**APPLICATION NO:** 21/00271/FUL/ADDINF

**DESCRIPTION:** Replacement of existing log cabin at the rear of the property.

**LOCATION:** 7 York Road Binfield Bracknell

Request nr: 201125.1VF - Bespoke cabin 4x5.5

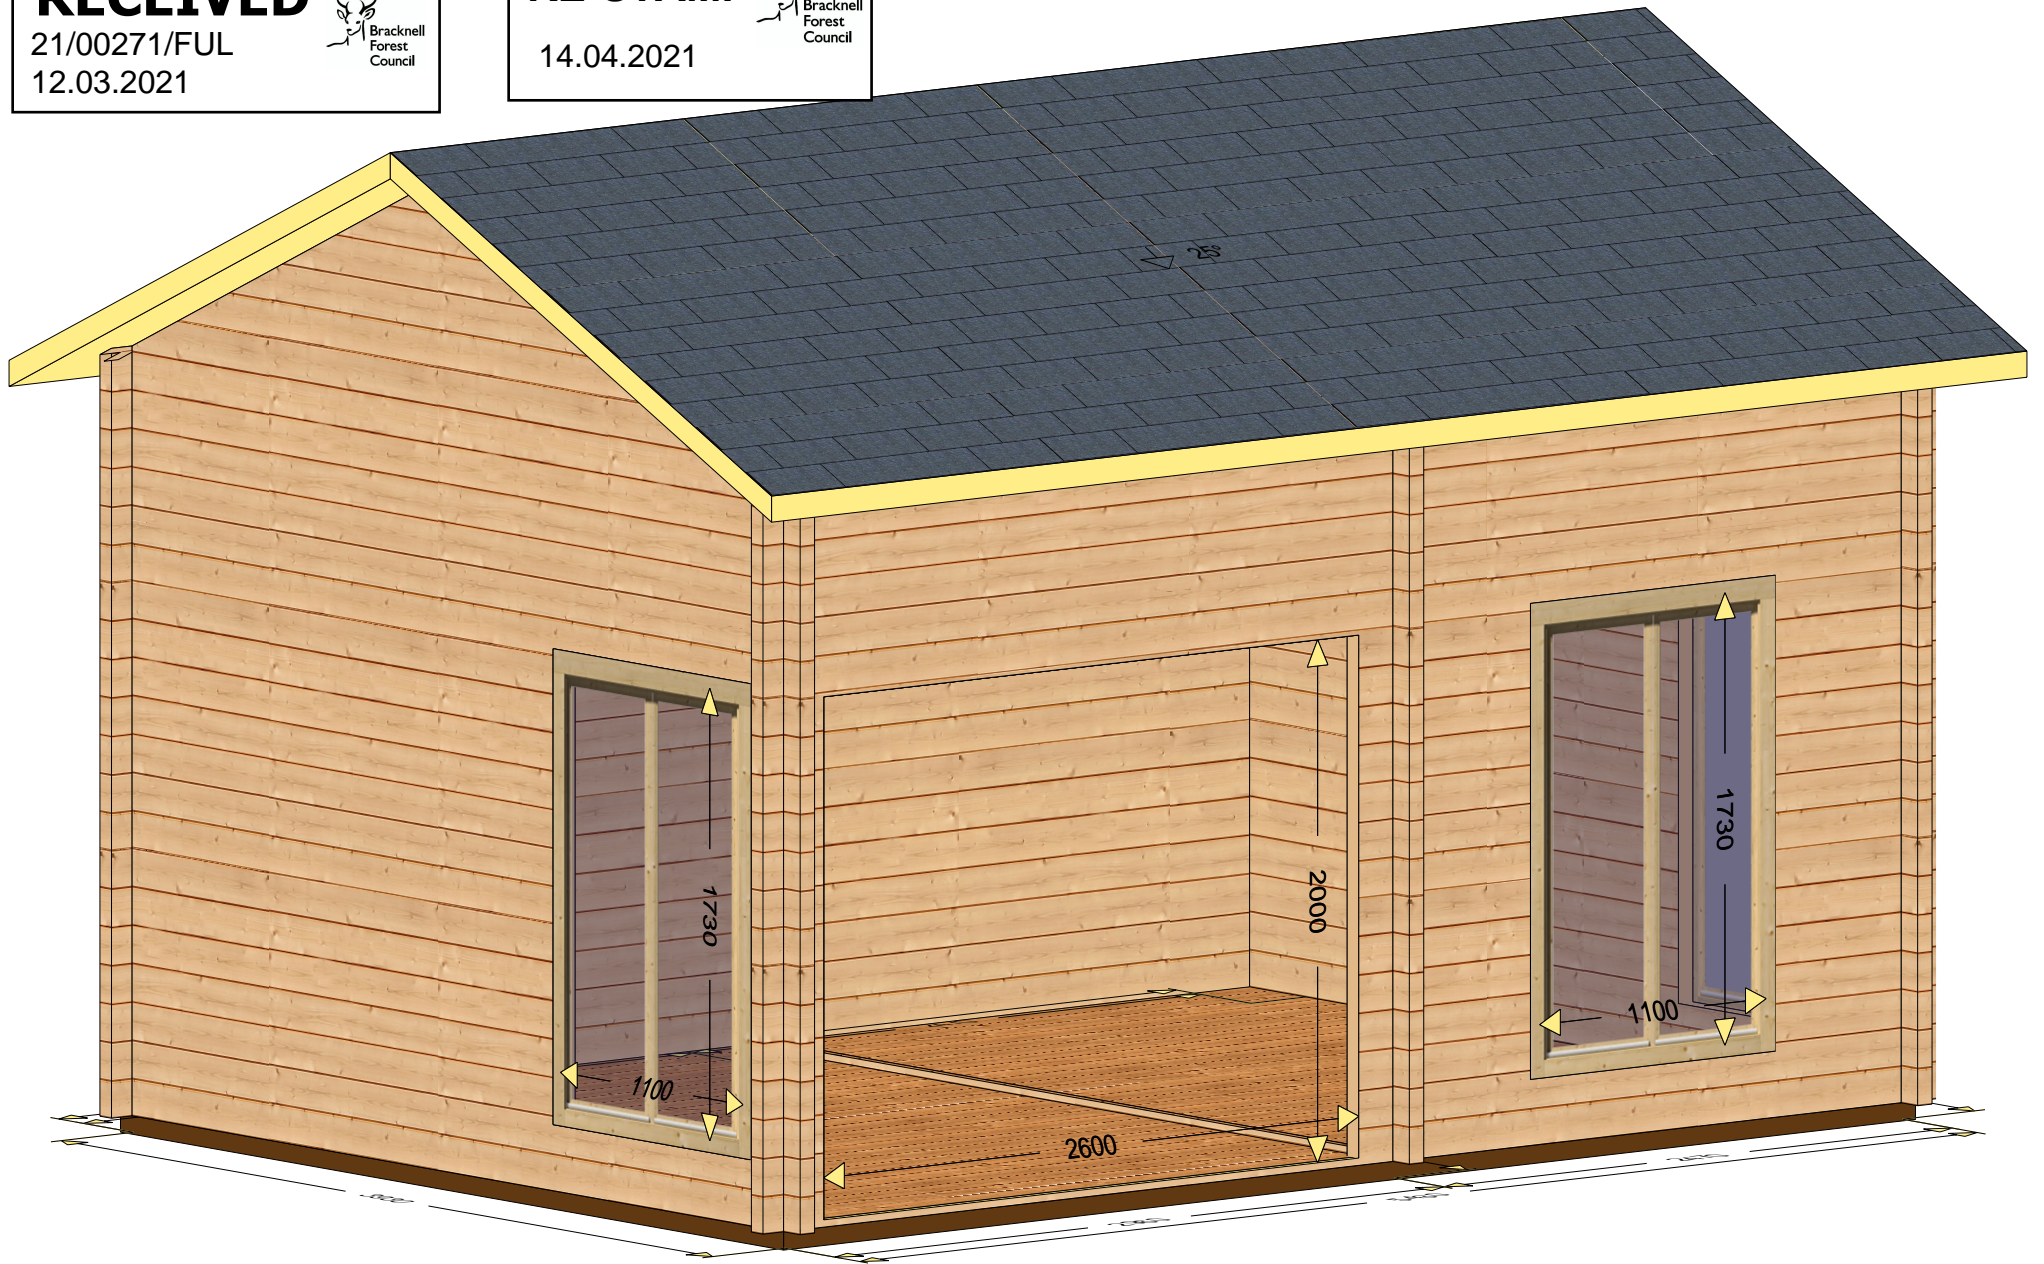
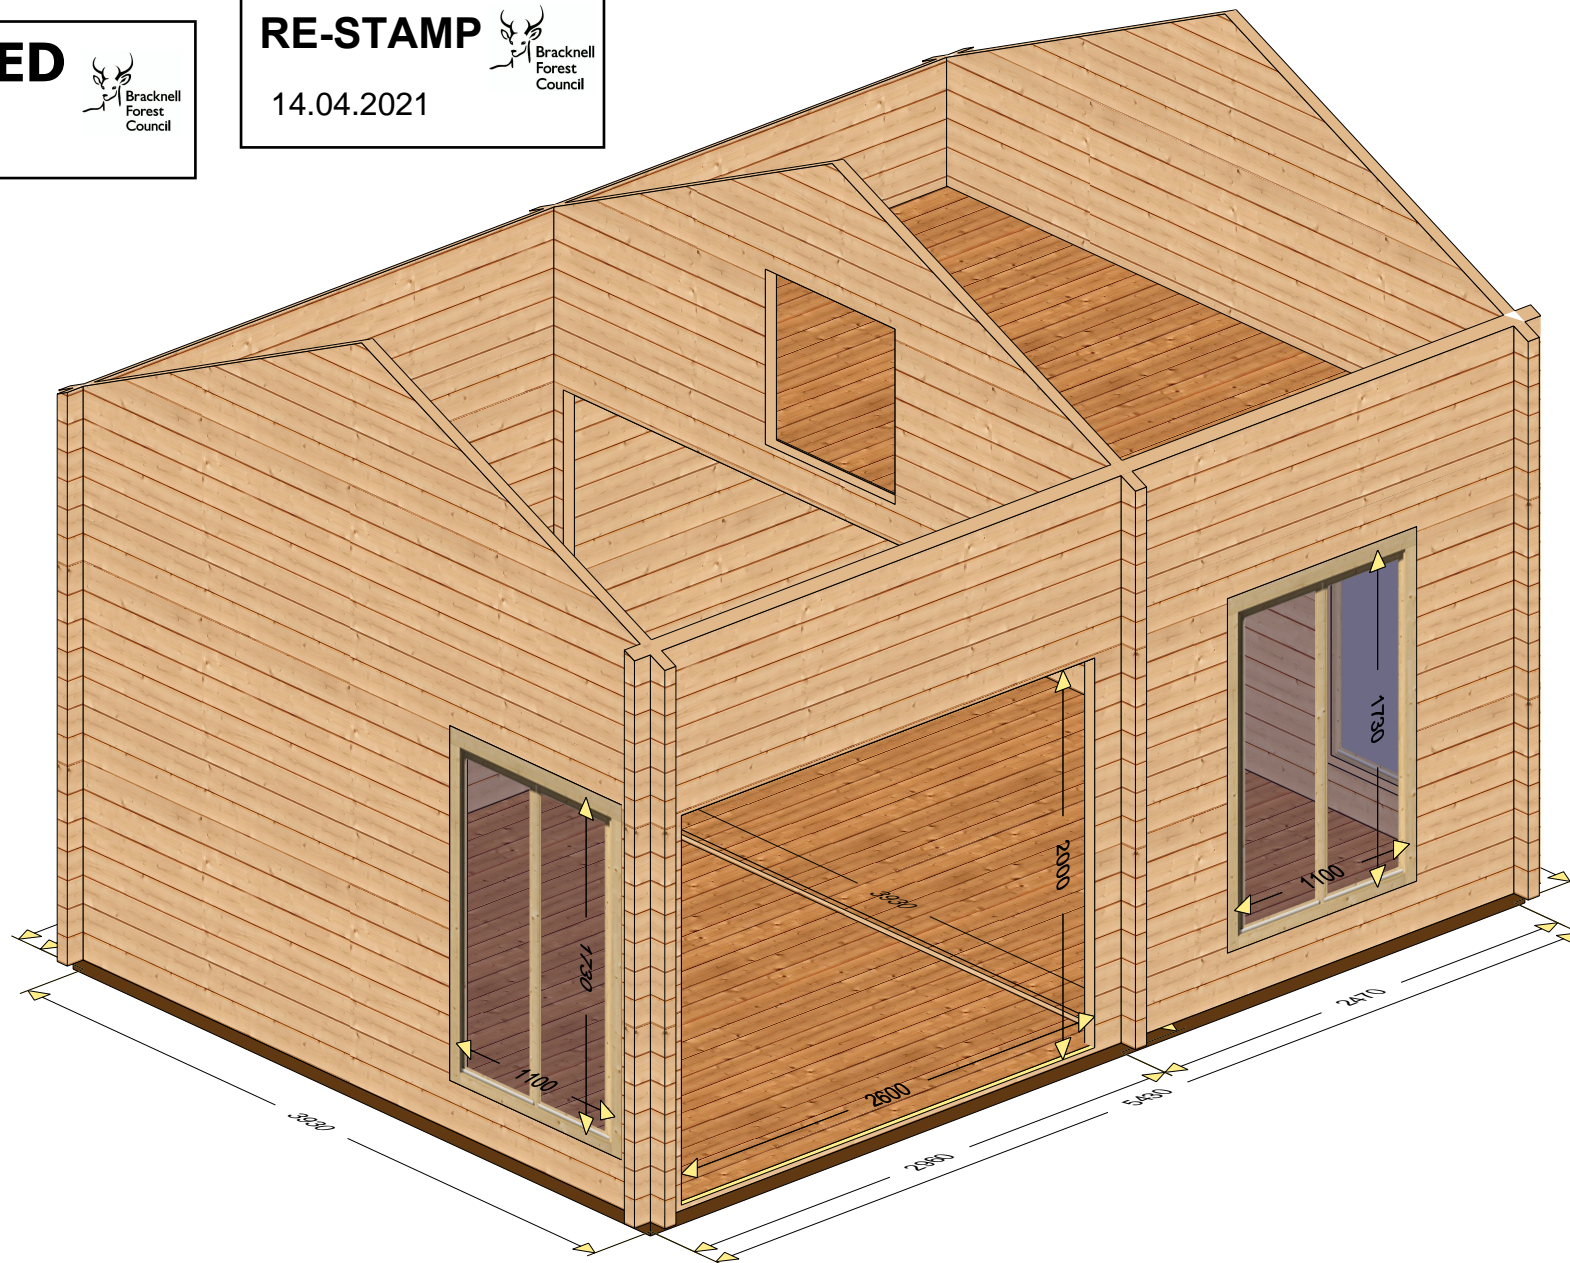
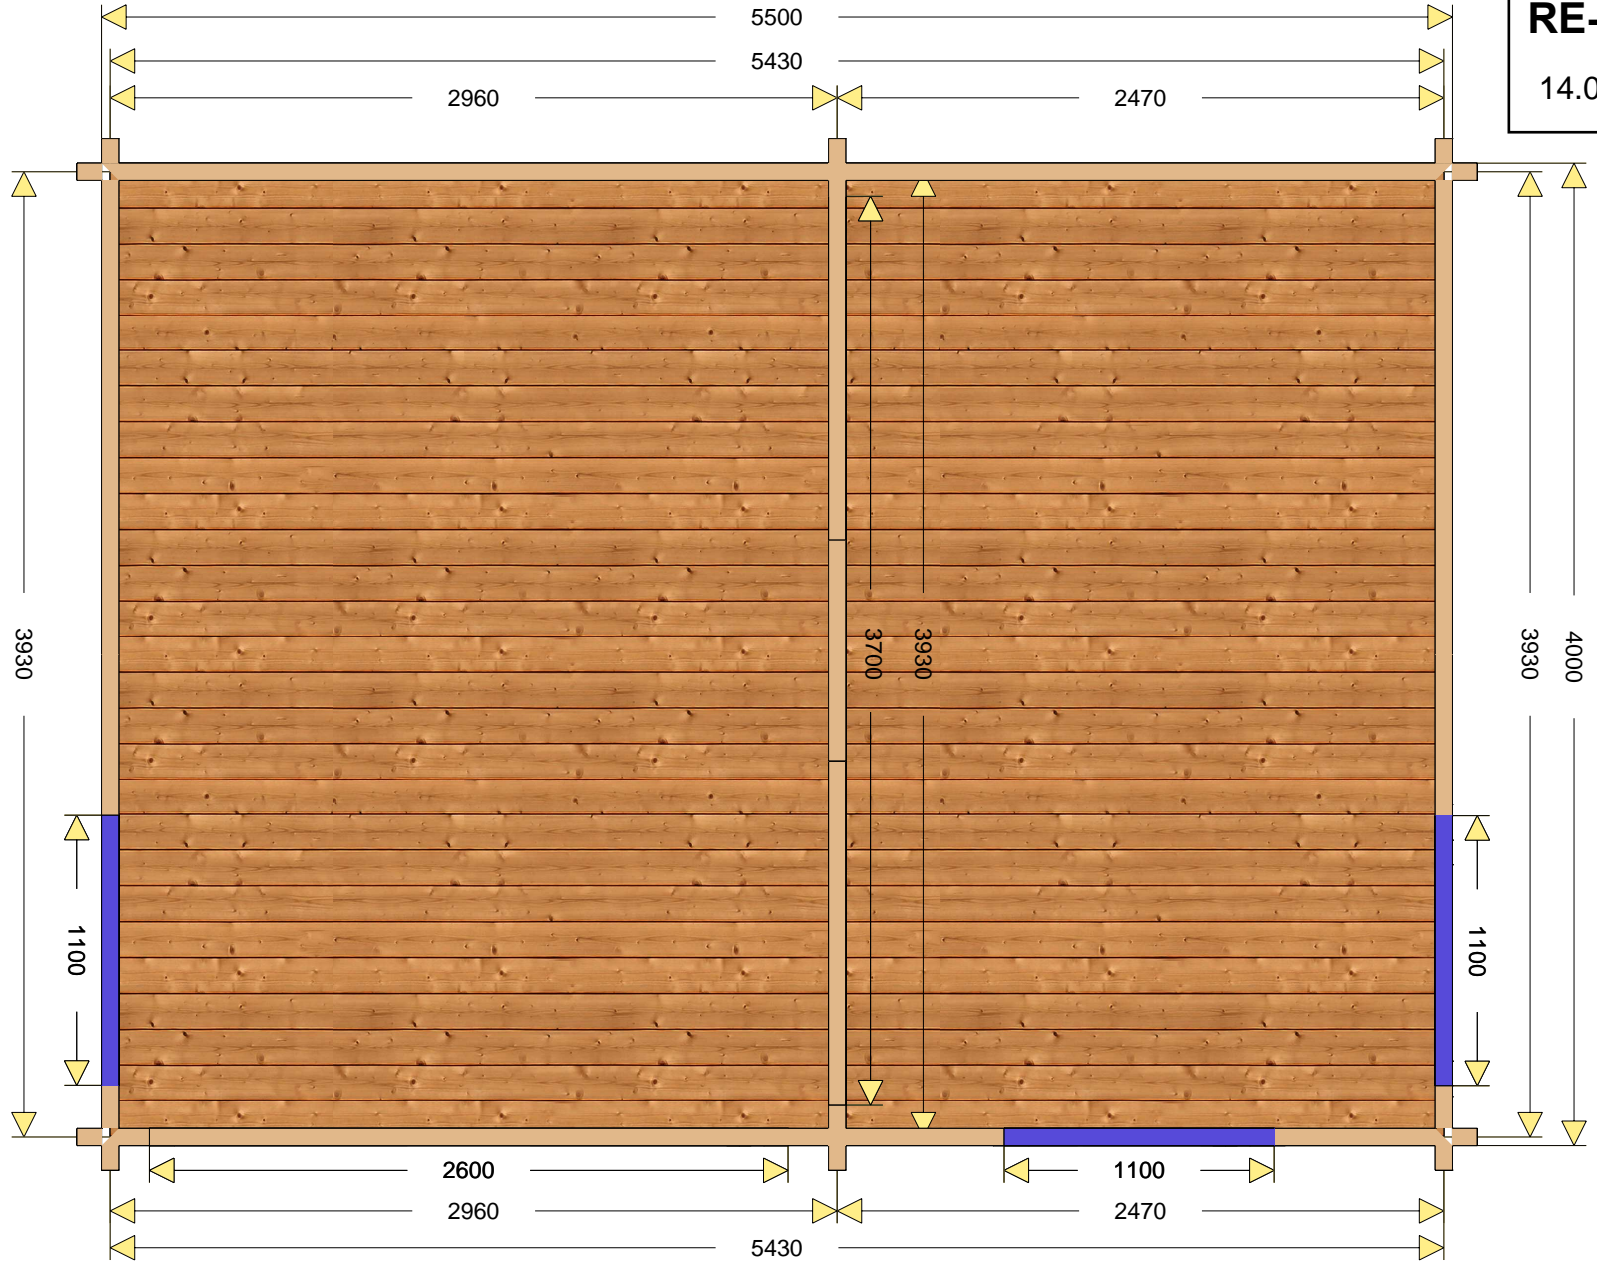
- 1 As the log cabin is close to the boundary than please can you confirm whether or not it will encroach on the adjoining property (e.g. the overhang of roof). If it does encroach you will need to complete Certificate B instead of Certificate A on the application form. We also require the maximum height of the cabin and the height to the eaves. This can be annotated on one of the drawings that you have supplied. Do not submit the amended / additional information s via the planning portal. Please submit by email directly to myself.
